## KITTITAS COUNTY COMMUNITY DEVELOPMENT SERVICES

Subject: Canyon River Ranch Conditional Use Permit (CU-12-02)

Subject: Conditional Use Permit Notice of Application Canyon River, Kittitas County

Re: CU-12-00002

Canyon River Ranch II
Proposed Conditional Use Site Plan

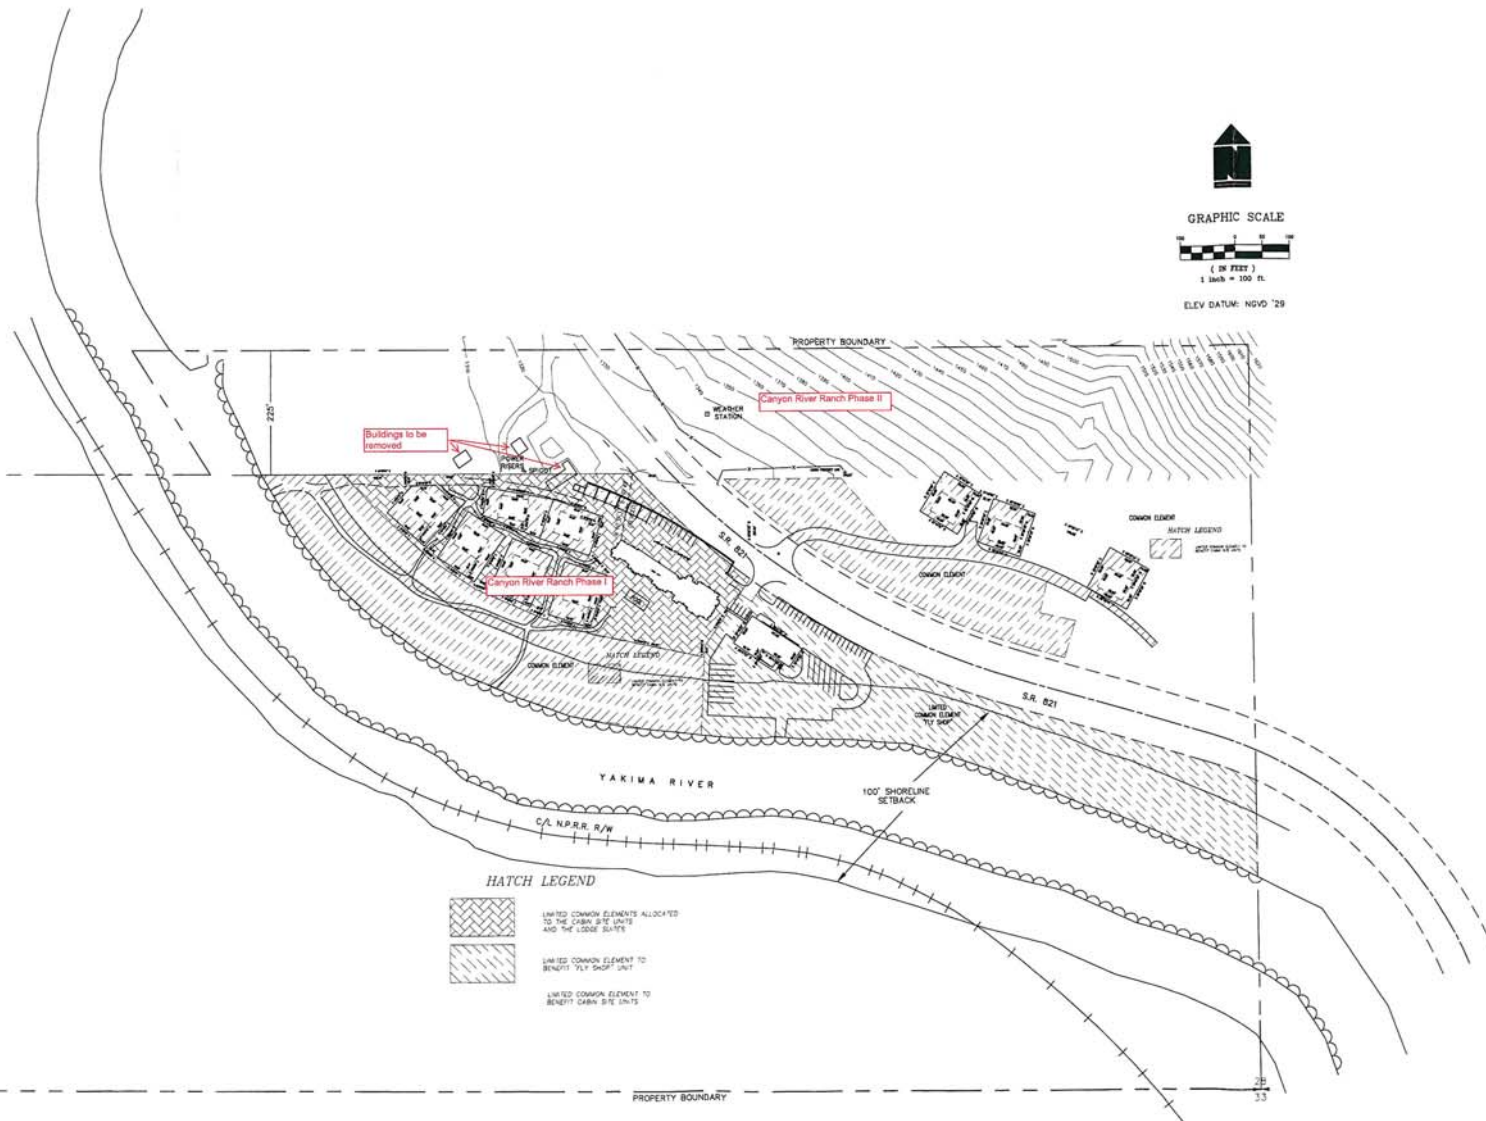
The location of the Ordinary High Water Mark, floodway and wetlands are crucial elements for determining whether a shoreline permit would be needed for this project. In section 3 of the SEPA checklist there is a statement that all work will be outside of the shoreline area. All development should be shown on scaled project drawings. Ecology would like to review the location of the OHWM and the location of wetlands on the ground because it appears that at least three of the proposed cabins and parking lots in the Proposed Zoning Conditional Use site plan (artists drawing) would be within shoreline jurisdiction and/or in floodway or wetland locations. In addition, according to our GIS information, as one moves north into the phase 2 area, the

floodplain and wetland edge locations move significantly to the east. The National Wetland Inventory Map shows a significant emergent wetland on both sides of the side channel in the phase 2 area. There is also a historic side channel to the east of the wetland which extends to the south into phase 1 from the property to the north. (It appears from aerial photo interpretation that there has been about 2/10 acre clearing or filling in this area in preparation for construction – if this is the case, then this needs to be identified on shoreline permit documents.) Ecology recommends that a floodway analysis be done for this project before any structures are built in the area of this side channel. Another option would be moving these structures to the other side of the highway as there is a lot of area available there for placement of cabins.

Site plans are confusing and distances from shorelines, side-channels and other riparian features are unclear. Septic reserve sites that rely on floodplain locations are a major concern. Septic fields need to be cleared for constructions and remain free from tree establishment in perpetuity. This is a long-term impact that can't be mitigated on site.

Impacts to a side-channel of the Yakima River, channel evulsion of that Yakima River and channel change from ice events or bed load is an issue. Lost (irreplaceable) opportunity for side-channel enhancement is a significant concern. Side channel habitat is extremely limited in the canyon. Infrastructure placement in the dynamic shoreline is a concern. River fighting to protect poorly placed infrastructure is a significant long-term concern. Shoreline management post constructions is an issue. Development density is a concern since more infrastructure is needed to service this larger development footprint.

- Stormwater and surface runoff generated by this project must be retained and treated on site and not allowed to flow onto WSDOT rights-of-way.
- The proposal includes an archery range near SR 821 and appears to be within range of an arrow. Prudent safety measures should be taken to ensure arrow(s) are prevented from flying onto WSDOT rights-of-way.
